SSD 6011 - Mixed use residential development within the South West Plot

Submission by:

Li Wang

31 July 2013

## Winter Solstice (21<sup>st</sup> June)

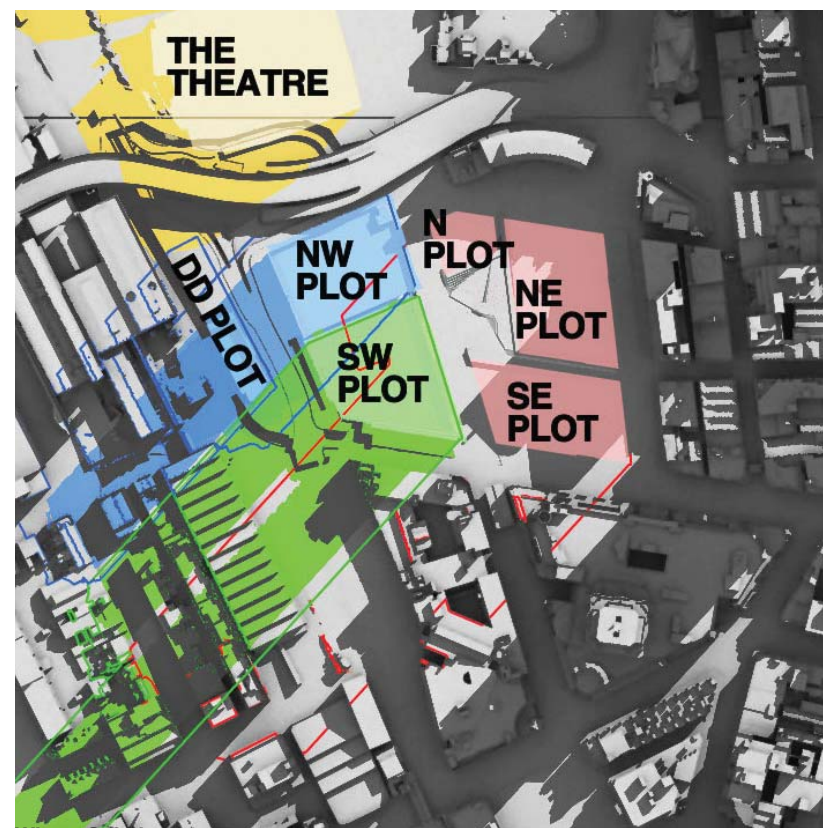
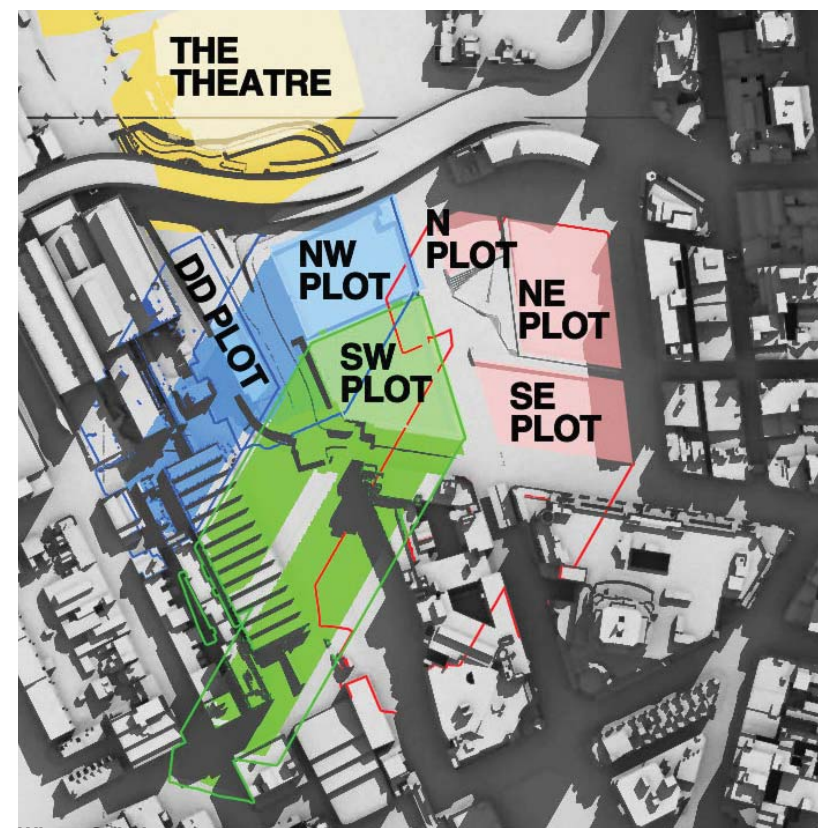
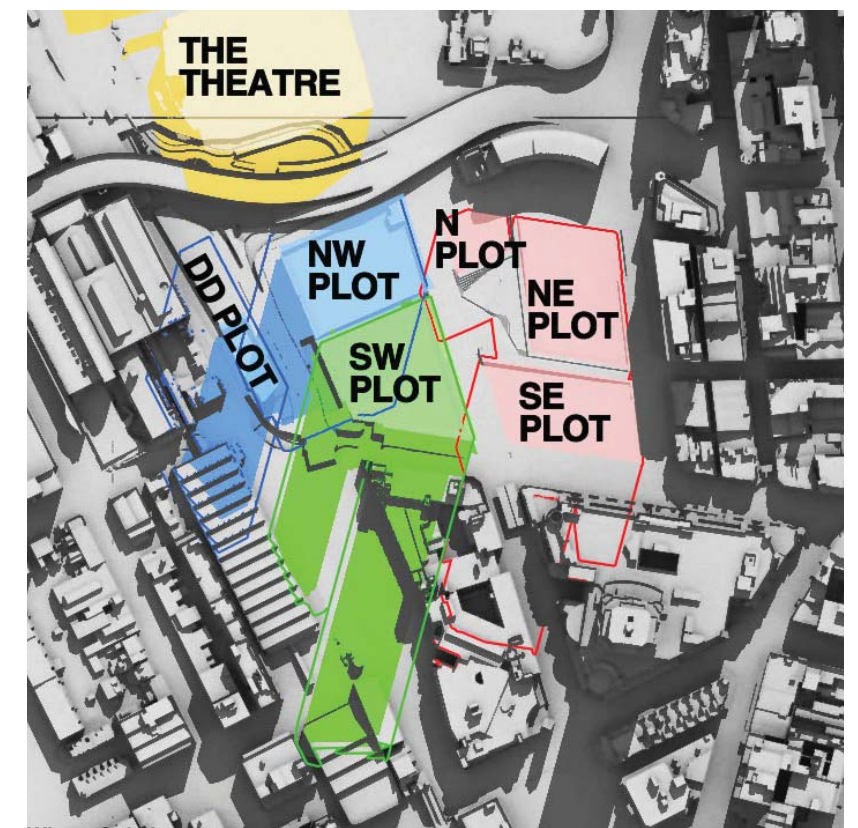
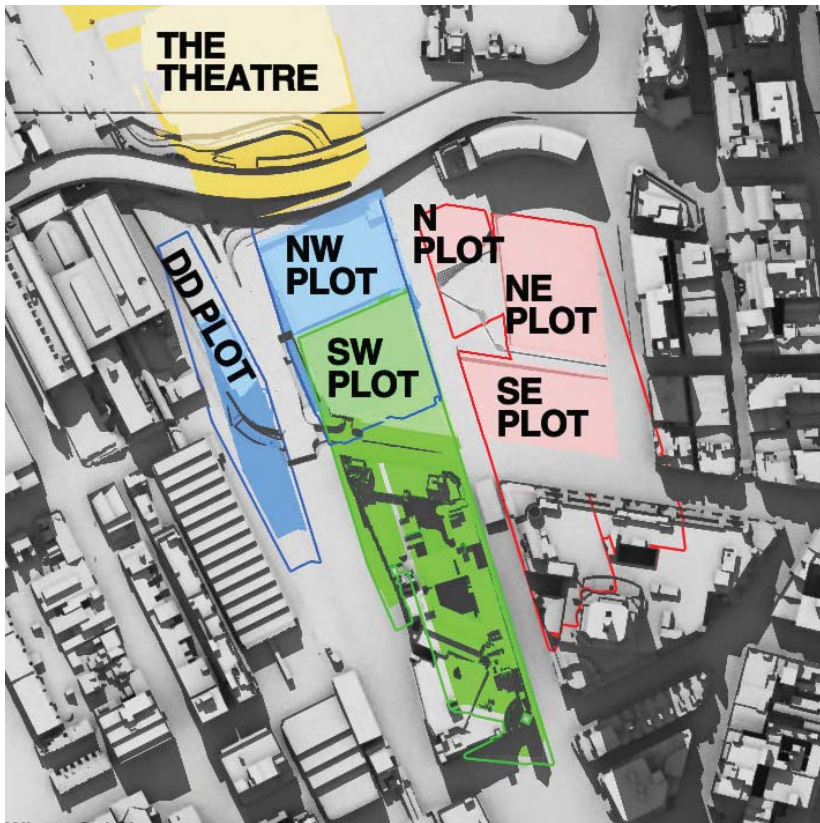
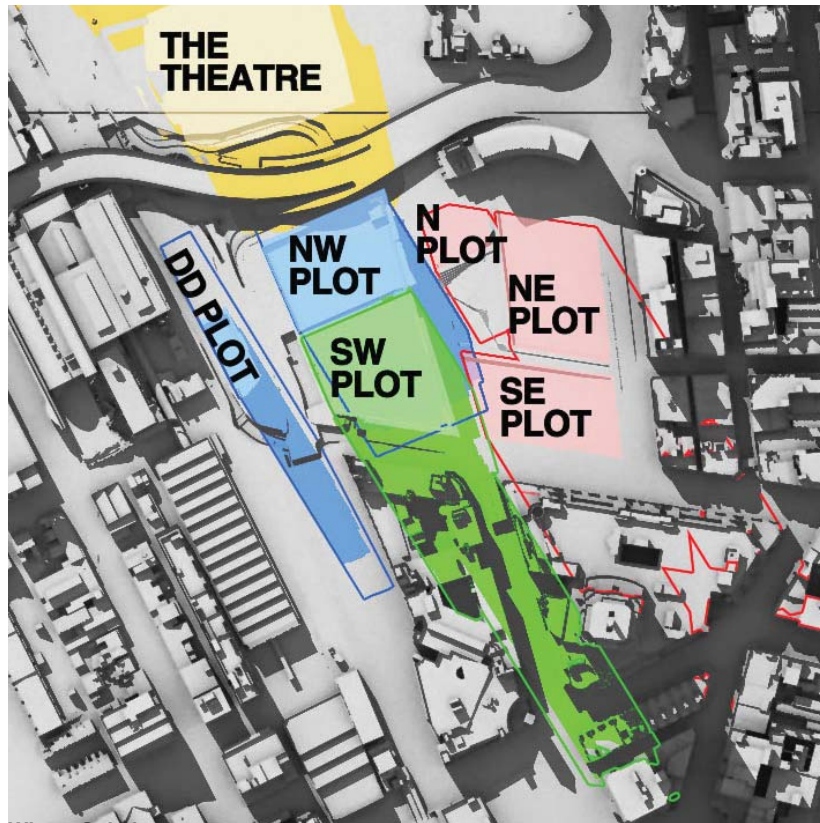
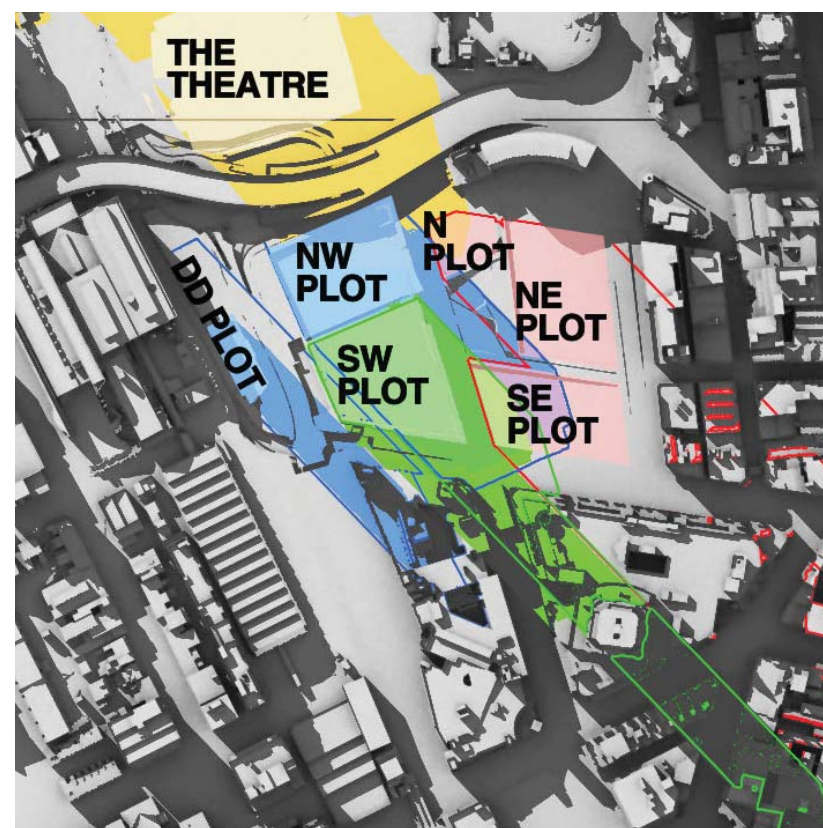
The proponent provides diagrams but fails to discuss the existing shadowing of the west façade of The Peak.

At 9am, 10am and 11am the west façade is totally in shadow due to other parts of The Peak building itself.

At 12pm there is still substantial existing shadowing on the west façade caused by the irregular shape of the west facade.

At 1pm the existing shadowing has been substantially removed, but not totally removed.

It can be concluded that some single aspect apartments on the west façade and some south-west dual aspect corner apartments currently receive less than 2 hours direct sunlight to habitable rooms and 50% of the private open space between 9am and 3pm on 21 June.

By 2pm the existing shadowing has been totally removed, but that is too late to achieve two hours of direct sunlight before 3pm.

At 1pm the existing shadowing has been substantially, although not entirely, removed. However, overshadowing of lower levels of the west façade by the concept proposal parameter plan shadows for the N,NE and SE plots has already started.

By 2pm the existing shadowing has been totally removed. However, overshadowing of the west façade by the SSDA4 and SSDA5 buildings has appeared and risen further up the west façade than the concept proposal parameter plan shadows for the N,NE and SE plots, which is still present.

At 3pm, the proponent states correctly that 45-45% of the western façade is overshadowed by the SSDA4 and SSDA5 buildings.

It can be concluded that, as a result of combination of the proposed development with existing shadowing of the west façade, some single aspect apartments on the west façade and the south-west dual aspect corner apartments which currently receive less than 2 hours direct sunlight to habitable rooms and 50% of the private open space between 9am and 3pm on 21 June will suffer additional overshadowing. It is beyond our skills to count the number of such apartments. We note that the proponent has made no attempt to do so.

Rather than counting the number of units which will not meet the DCP guidelines, the proponent attempts to trade-off direct sunlight at 4pm for lack of direct sunlight during the period 9am to 3pm. There is no provision in the DCP guidelines for such a trade-off.
